SSD 5300 MOD 2 – 50 Wyllie Road, Kembla Grange – EPA Comments

I am writing to you about the Department of Planning and Environment's (DPE) request for comments for the Modification Application for the Kembla Grange Resource Recovery Facility, SSD 5300 MOD 2 located at 50 Wyllie Road, Kembla Grange (the Premises). The Environment Protection Authority (EPA) has reviewed the application and supporting documentation and provides the following comments and proposed consent conditions:

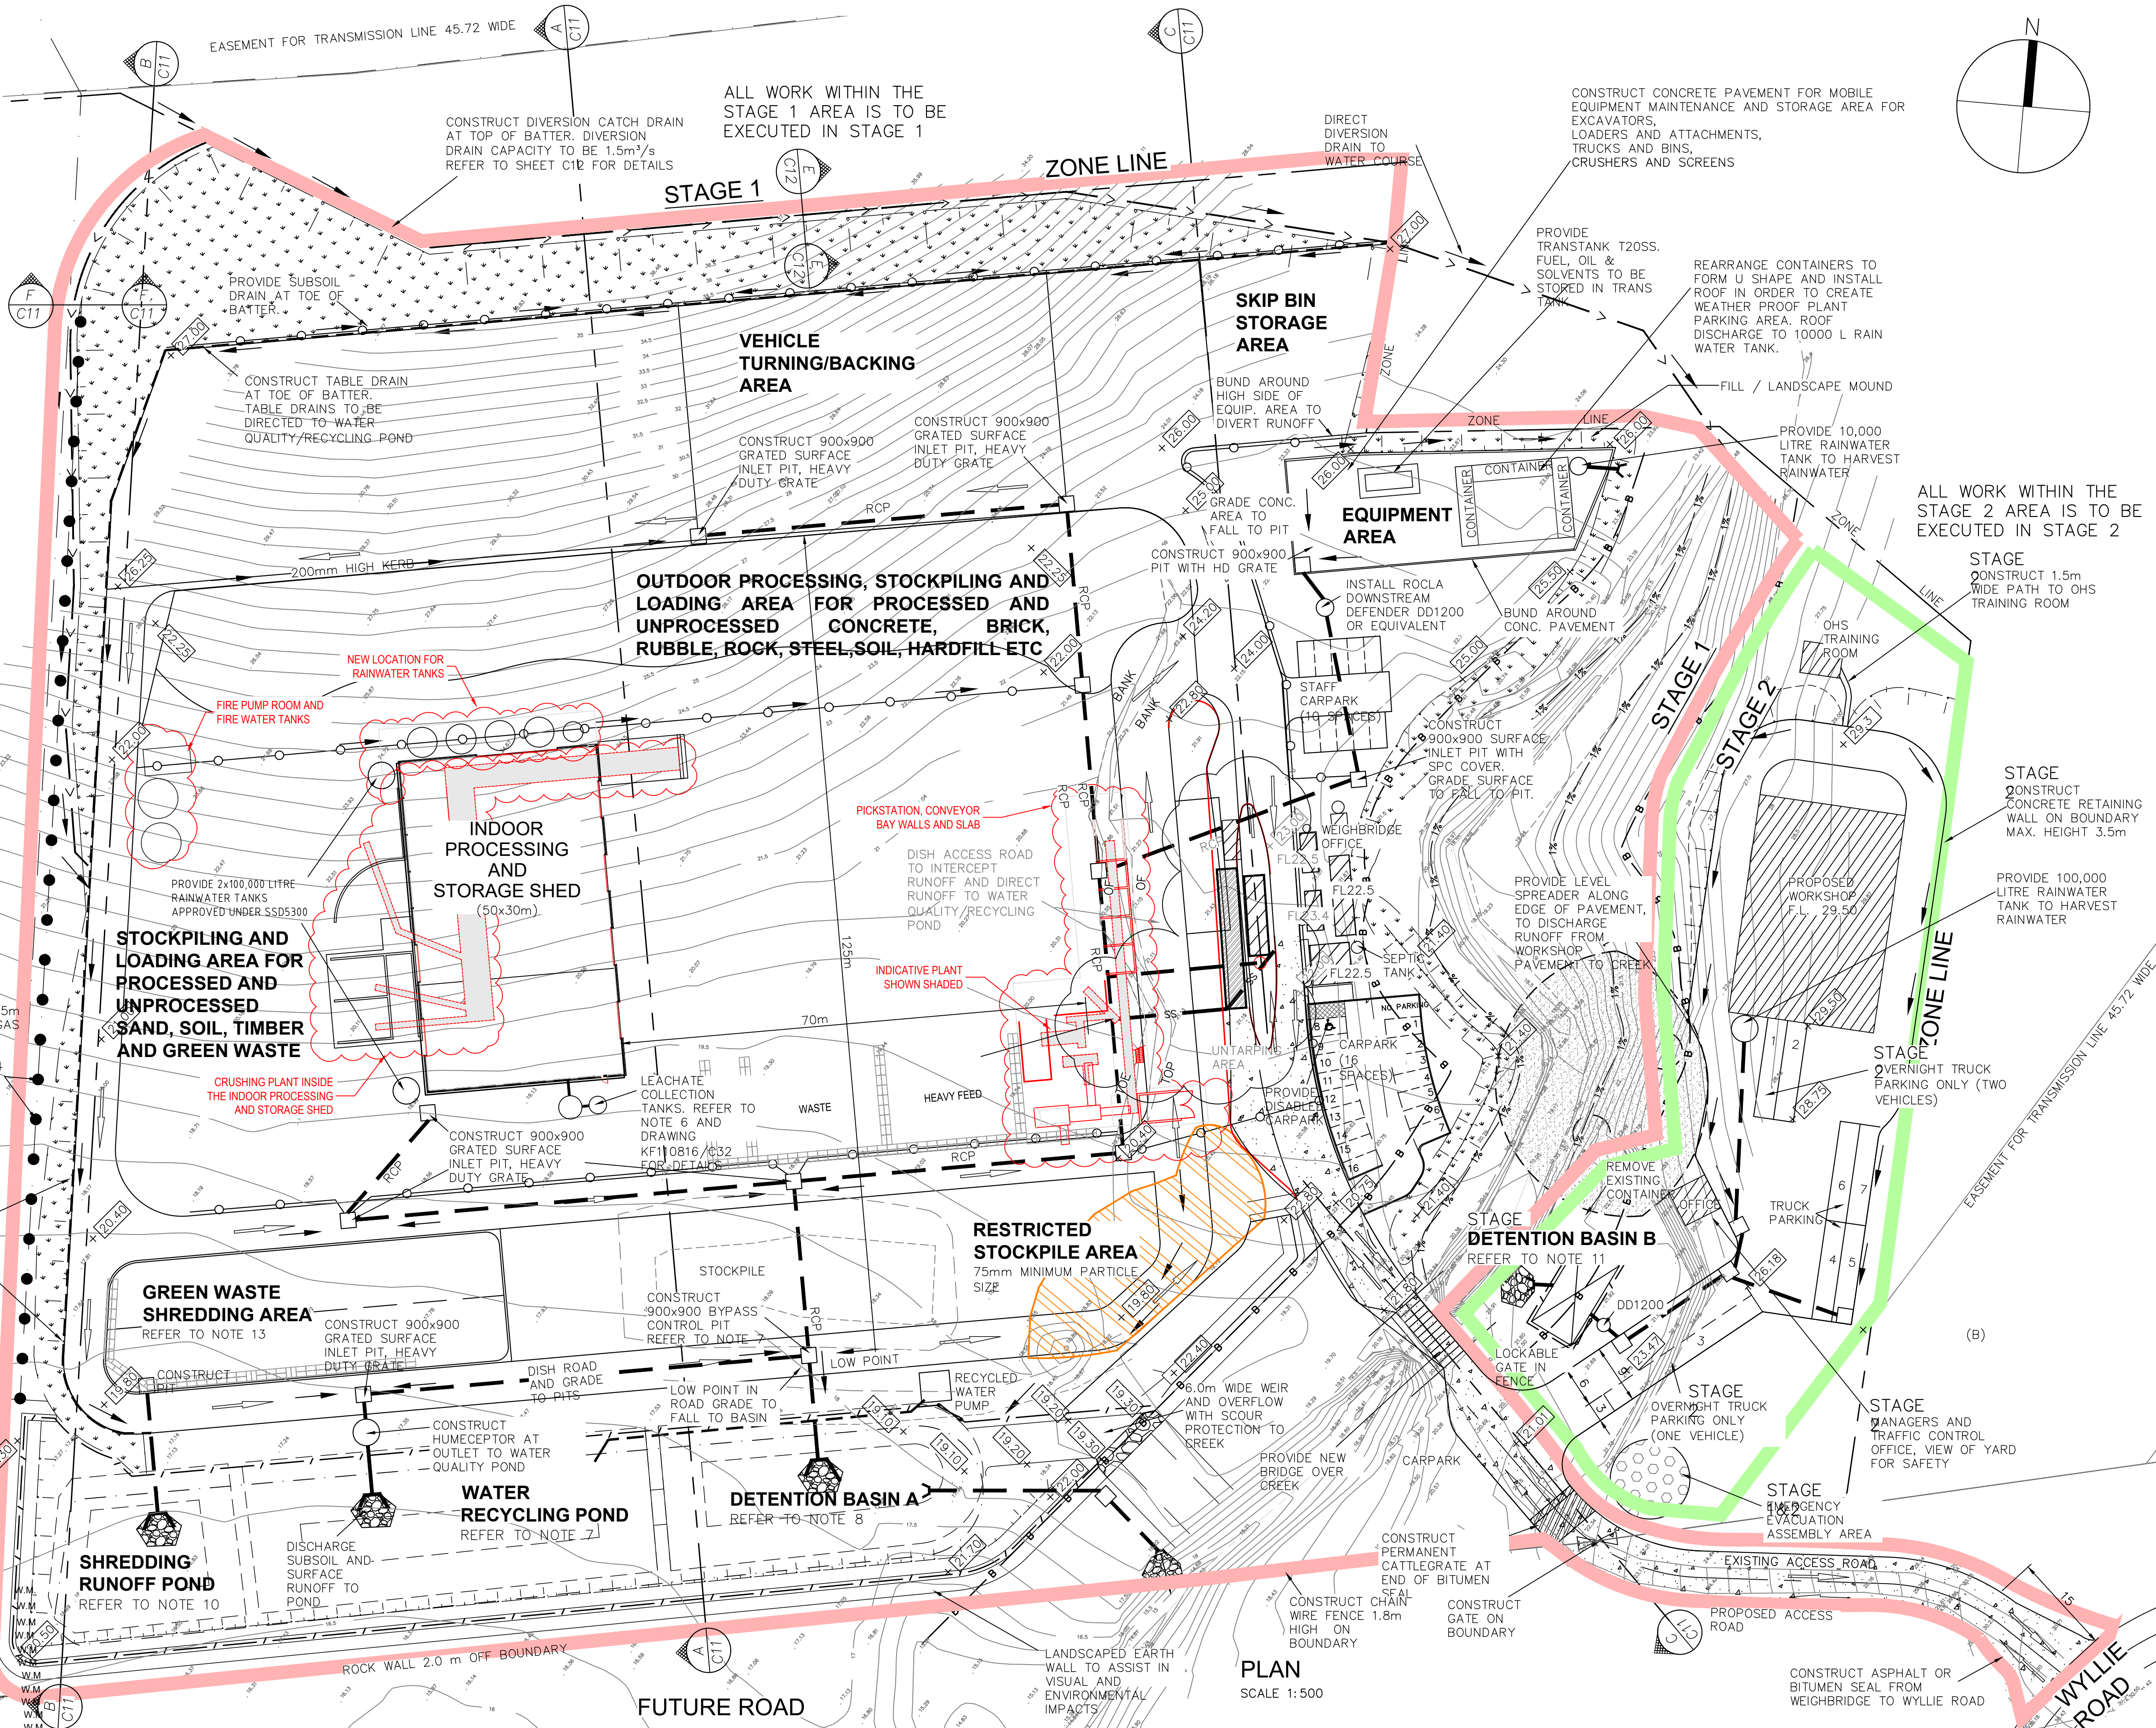
Given the proposed changes to site operations, which include an outdoor picking station, we recommend that the applicant be required to assess the adequacy and suitability of the current leachate and stormwater management system.

We note that the drawing titled *Proposed Industrial Development, Lot 10 DP 878167, Wyllie Road, Kembla Grange, Site Plan, Drawing No. C10* prepared by KFW and dated 7 November 2012 shows a stormwater pit located in close proximity to the picking station where waste will potentially be stored.

5. The applicant must provide an updated leachate and stormwater management plan and associated diagrams to DPE and the EPA.
6. All segregated garden waste must be stored and processed in the area labelled "Green waste shredding area" on the drawing titled *Proposed Industrial Development, Lot 10 DP 878167, Wyllie Road, Kembla Grange, Site Plan, Drawing No. C10* prepared by KFW and dated 7 November 2012.
7. Waste must not be stored or stockpiled on any stormwater pit at the Premises.
